Please ask for: Mrs D Johnson
Email: daun.johnson@arun.gov.uk
Telephone: 01903 737762
Our Ref: BR/56/25/HH
Your Ref:
Date: 2nd April 2025

Application for Planning Permission for Works or Extension to a Dwelling

Development: Demolition and replacement of garage with small extension in internal area and creation of habitable space above, changes to depth of upper first floor front window, addition of 2 No roof windows to existing building and PV panels on South elevation.

Location: 30 Madeira Avenue Bognor Regis PO22 8DB

Block Plan: 30 Madeira Avenue PO228DB: re-build garage with extension above

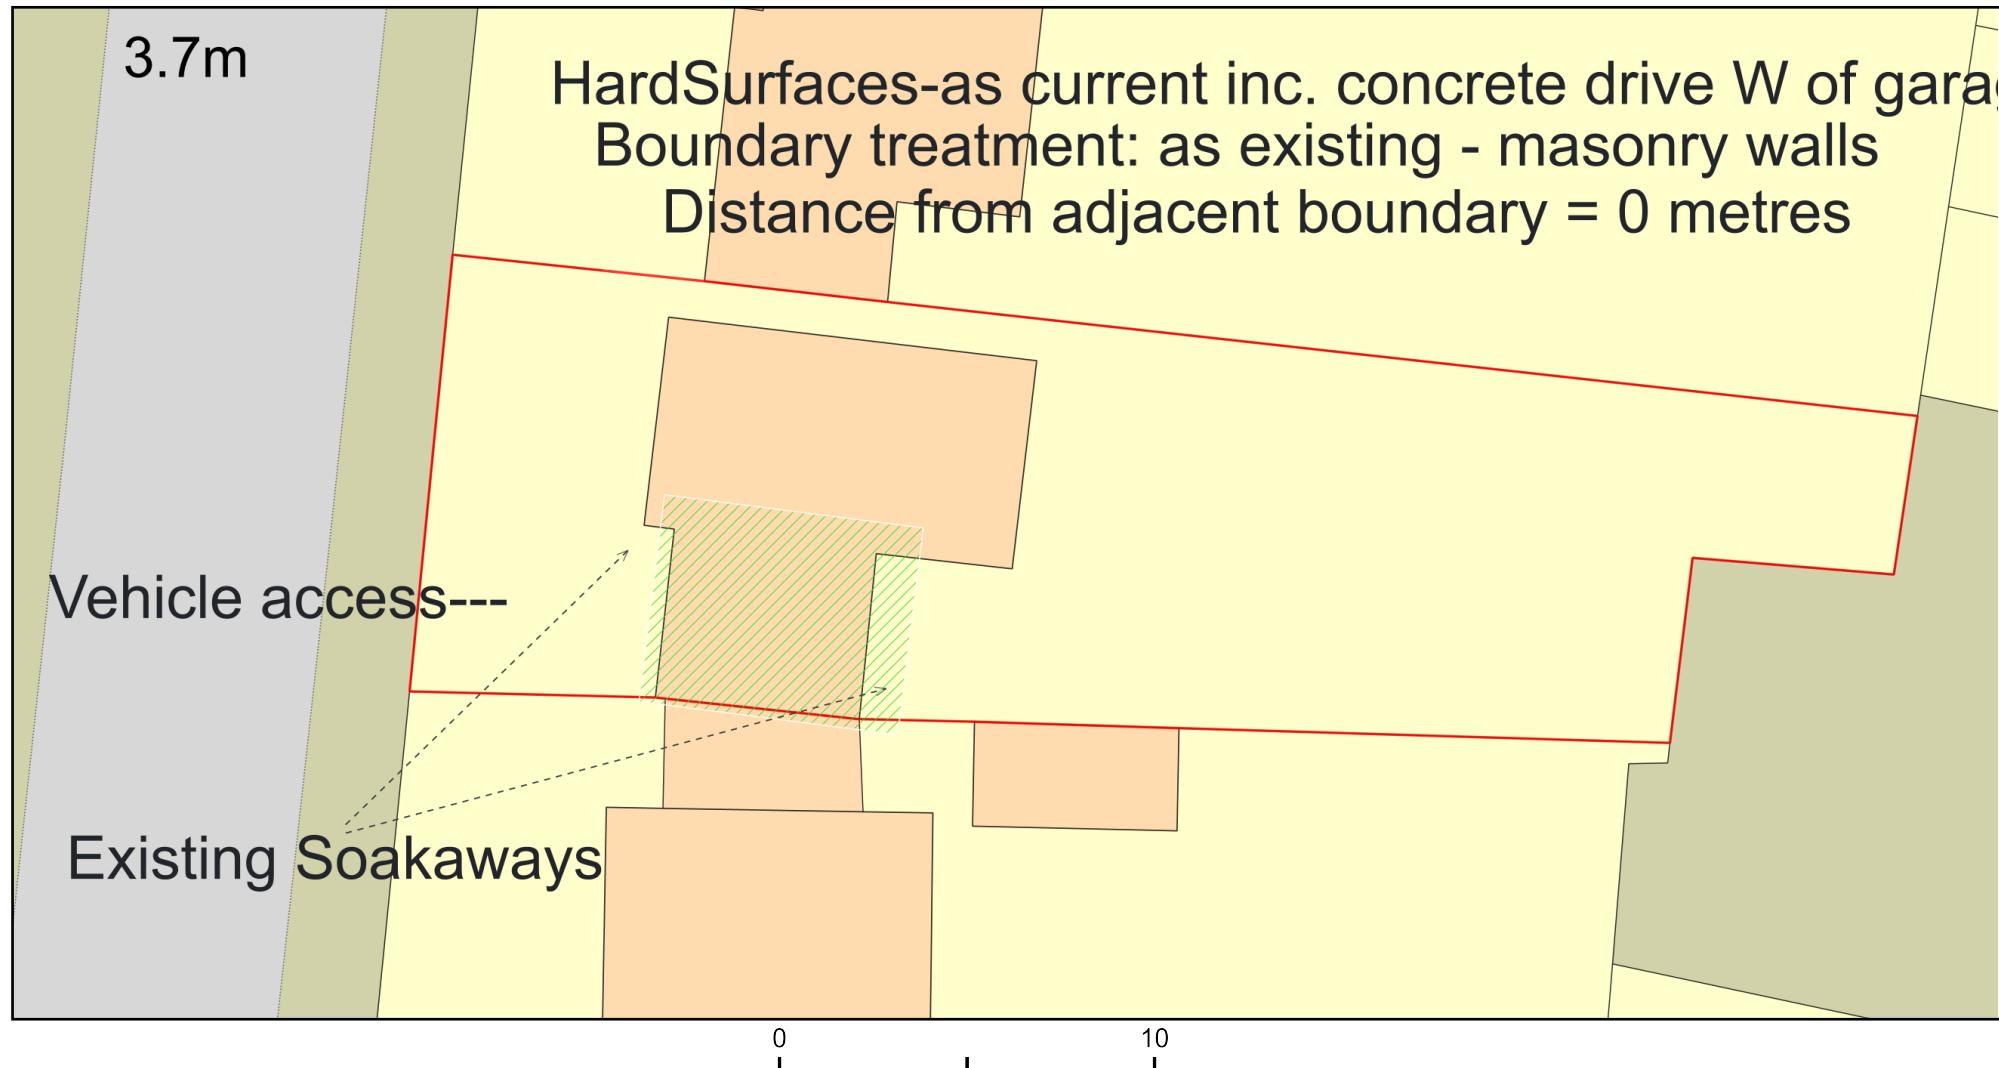
Please provide one named road.

30, Madeira Avenue, P0228DB :: South side Elevation : Proposed

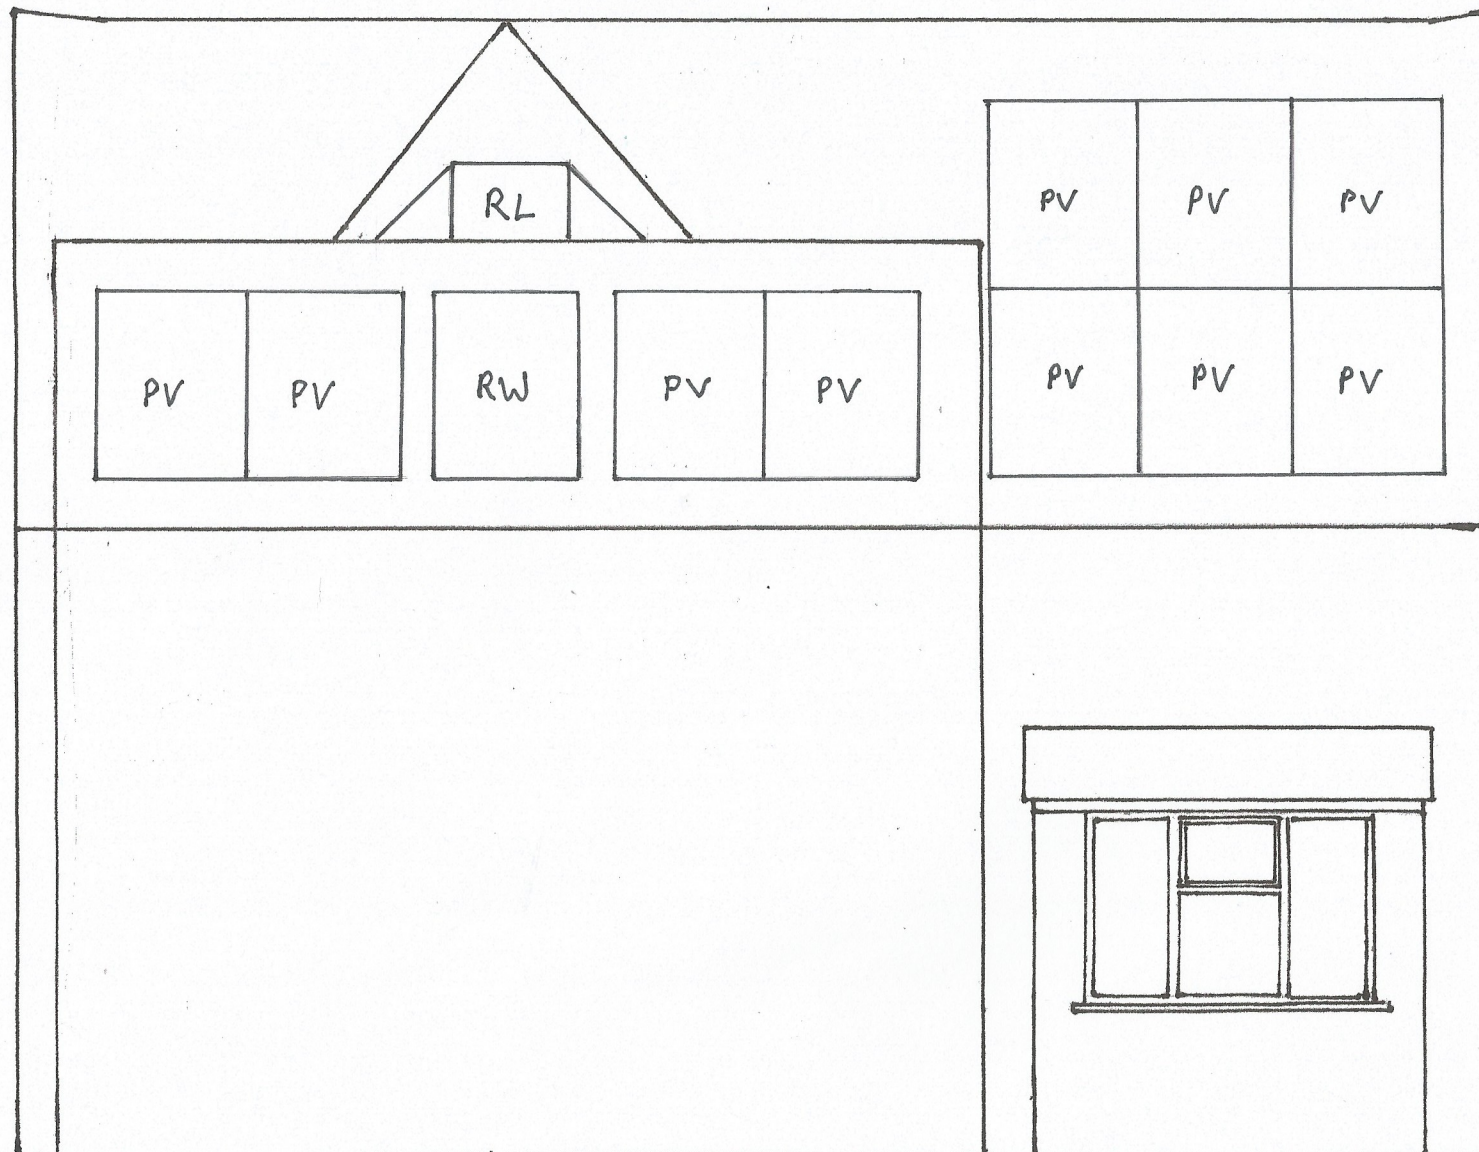
The proposed floor plan for the habitable space above the garage does not accord with the proposed elevations. Please show all windows on the floor plan to match the proposed elevations.
